SUBJECT: 2486 84th Ave SE
Mercer Island, Washington
RE: Plan Review Comments
Griffith Residence Deck Expansion

The following are our responses to The City of Mercer Island's plan review comments for the above referenced project.

SECTIONS
A4.01

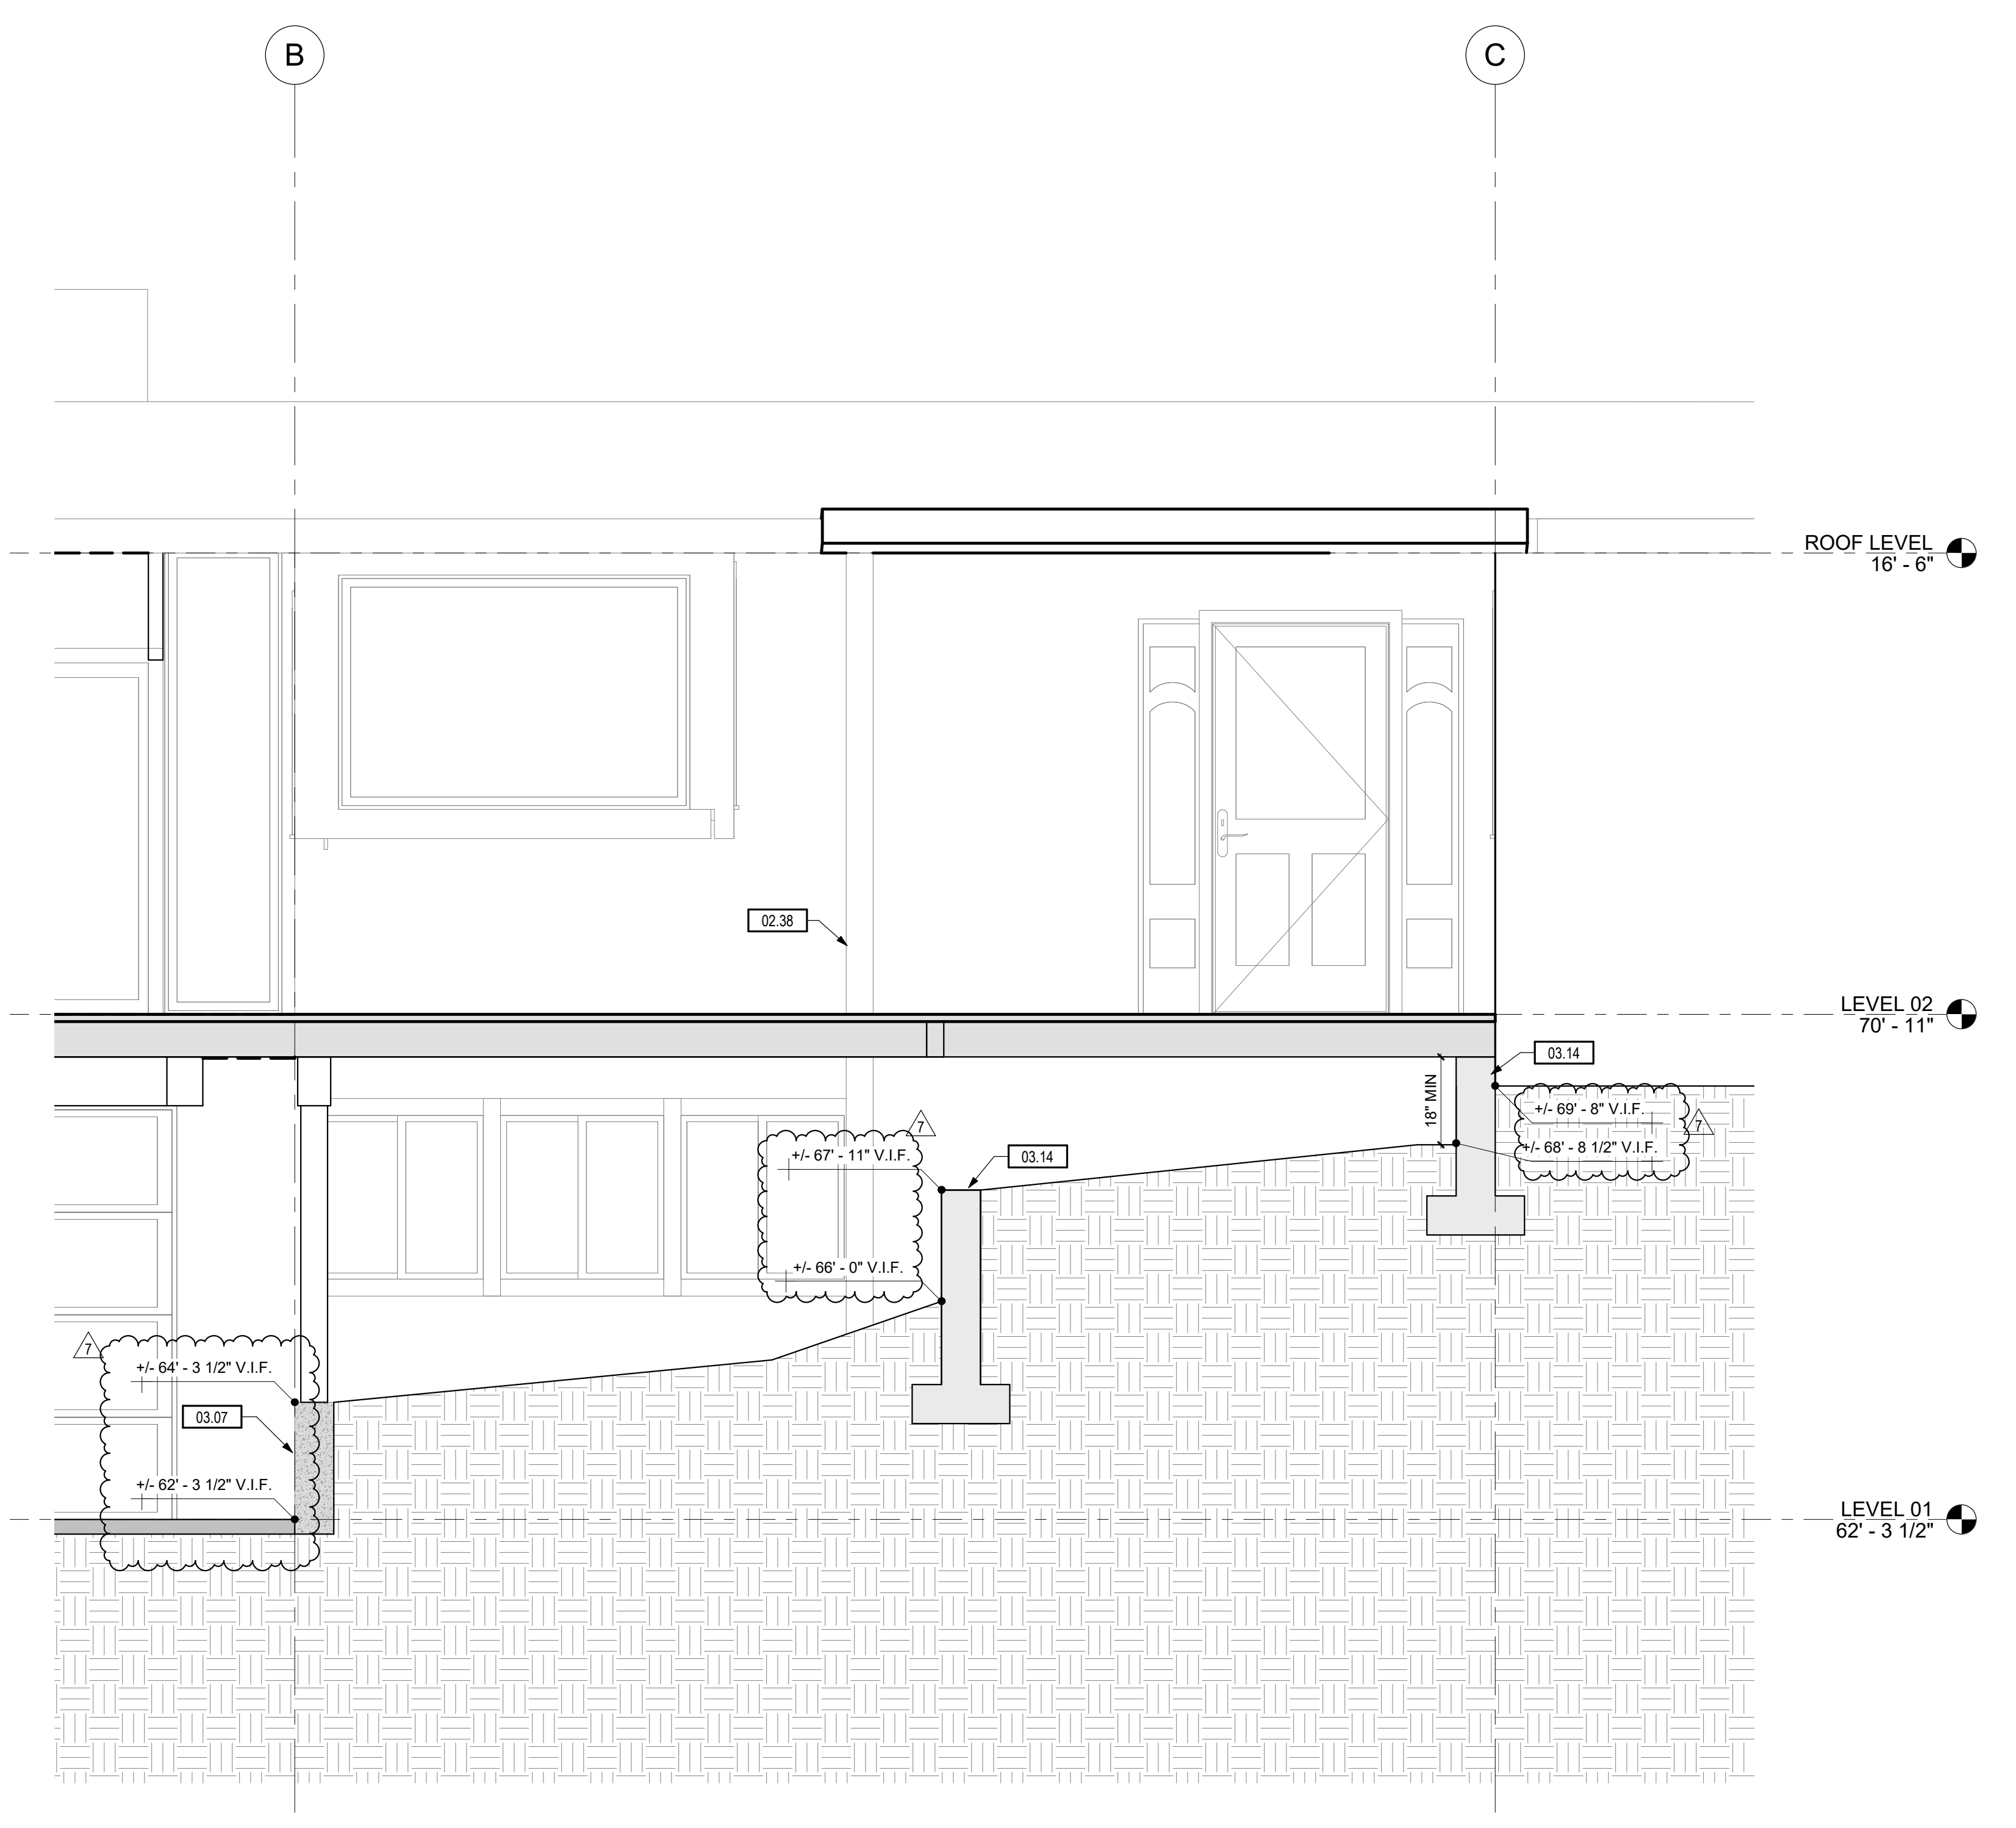
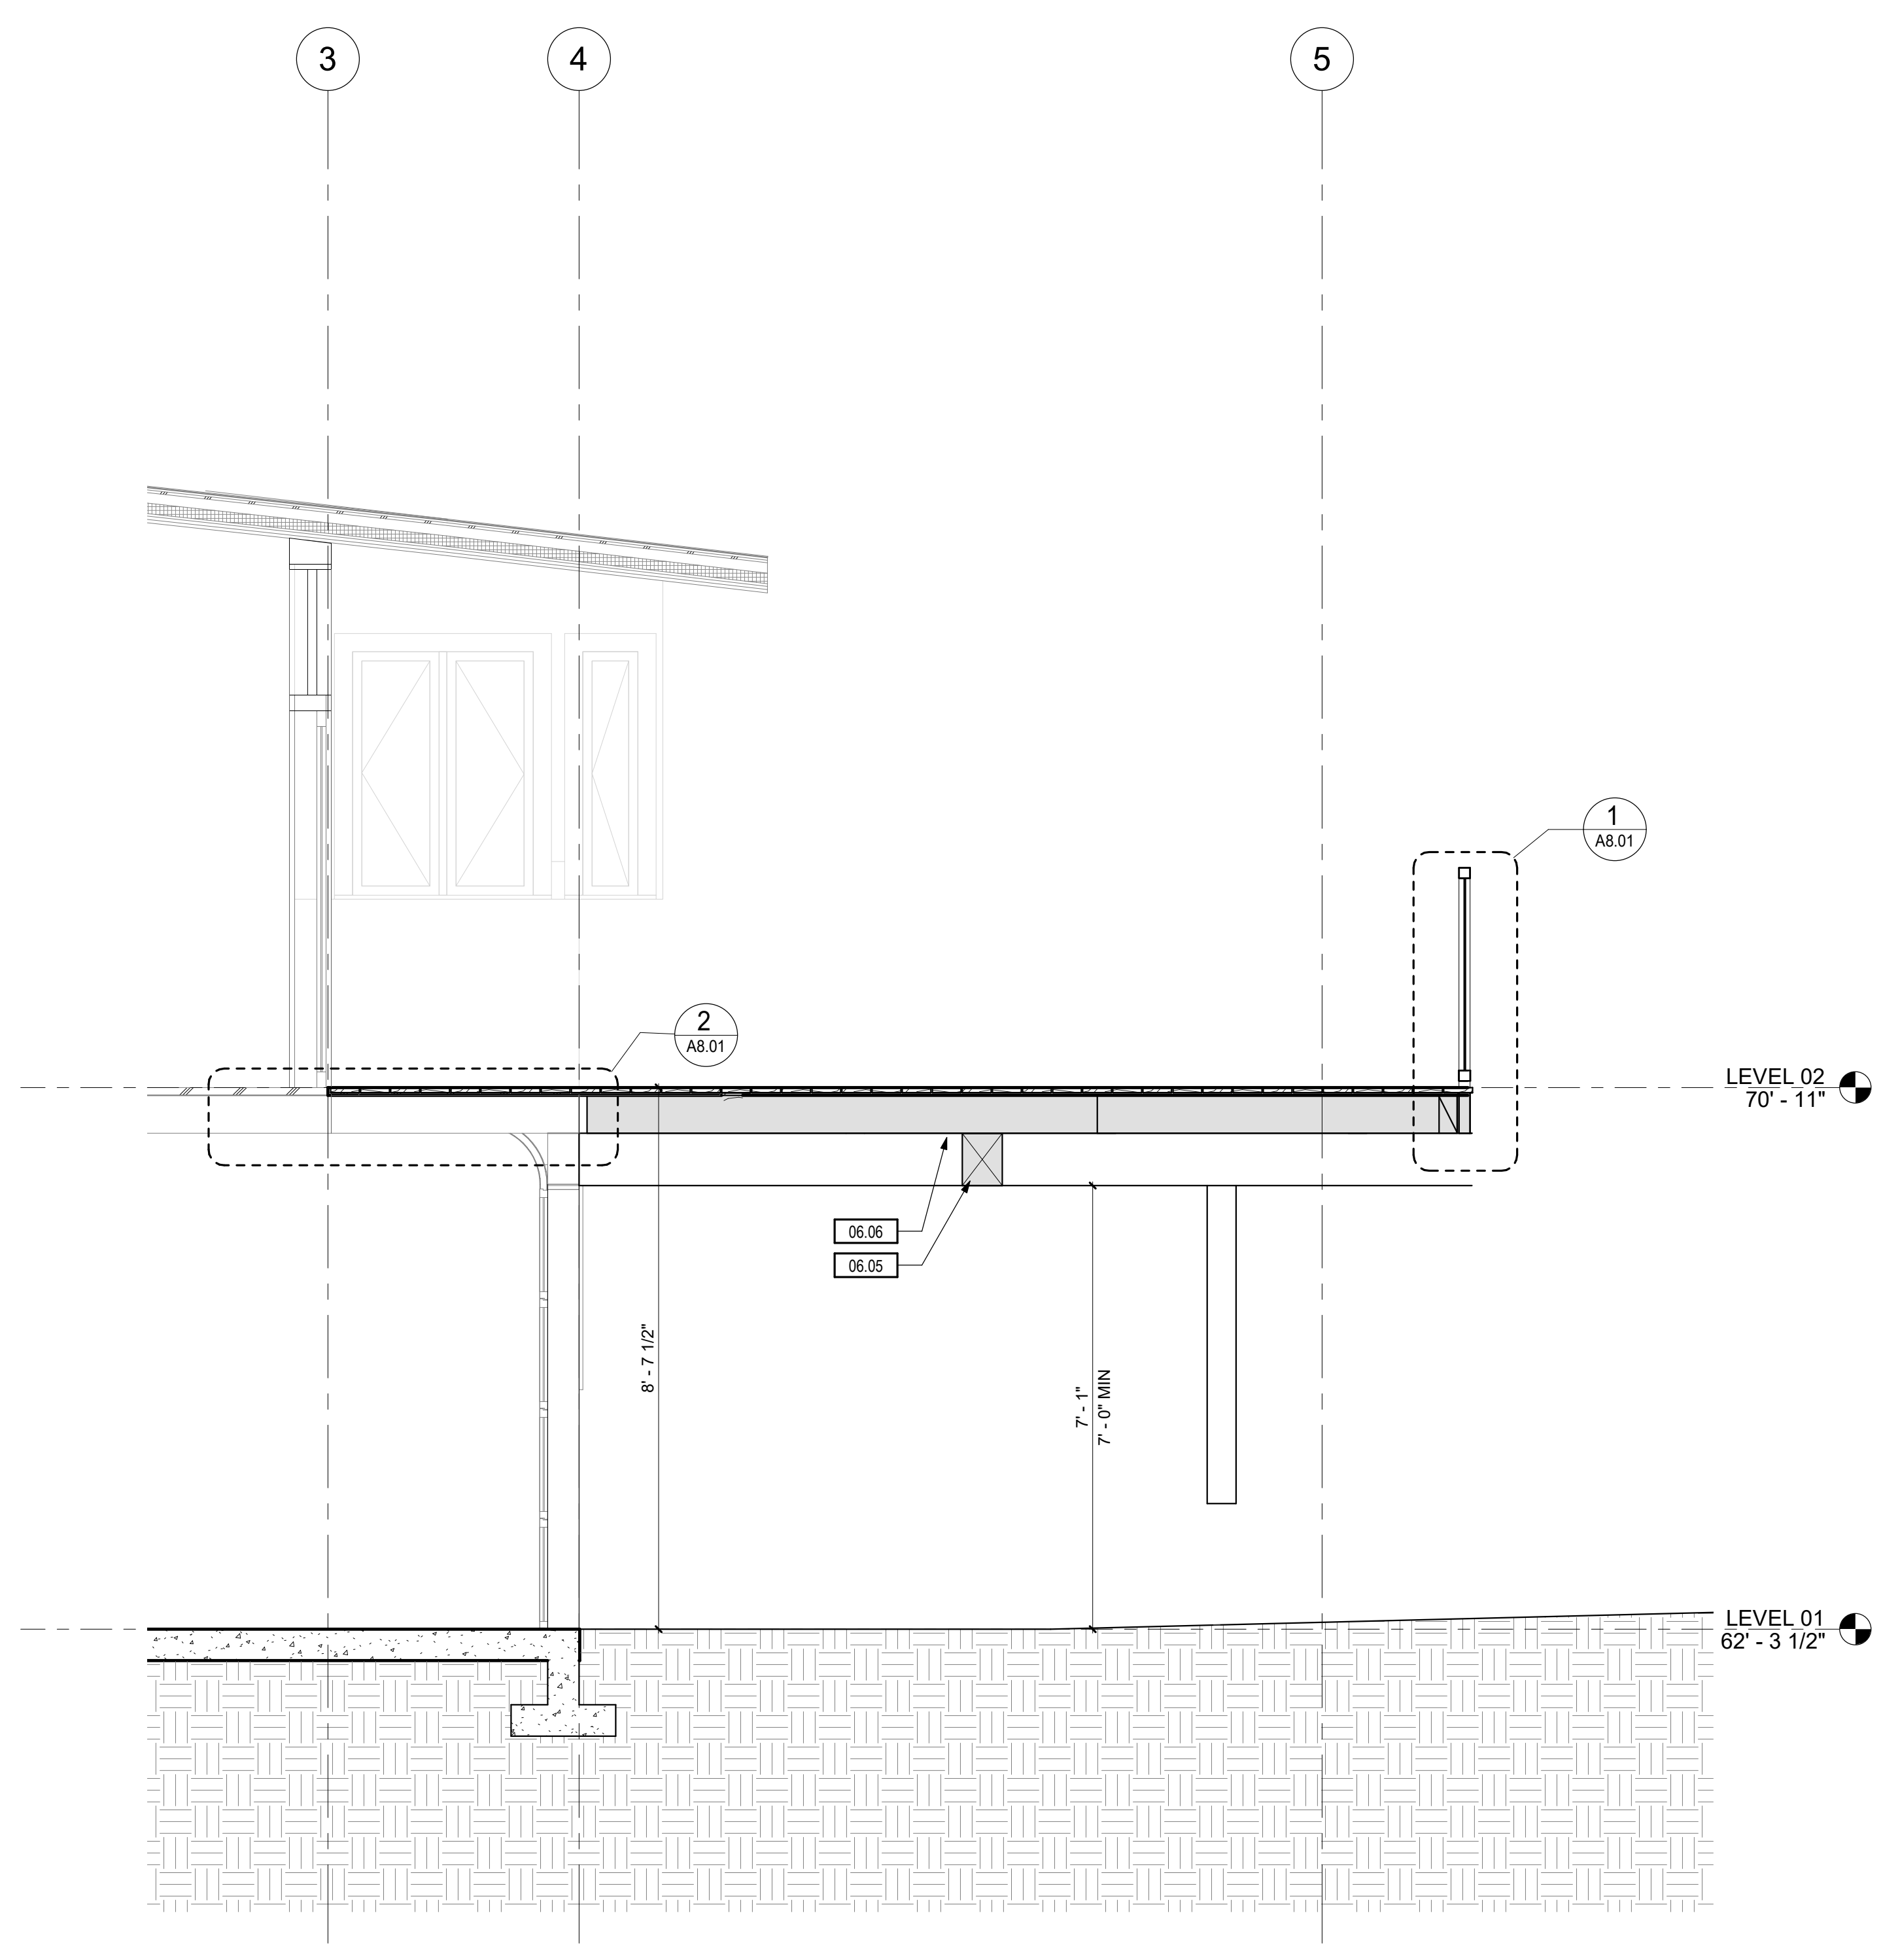
1. This note has been revised to call out detail 6/S4.2, only. The detail occurs at the GLB bearing on the new retaining wall.
2. Per arch elevations, and new section 2/A4.01, grade will be 15" below top of deck. Per IBC 1015.2, a guard is only required where elevation difference is over 30".
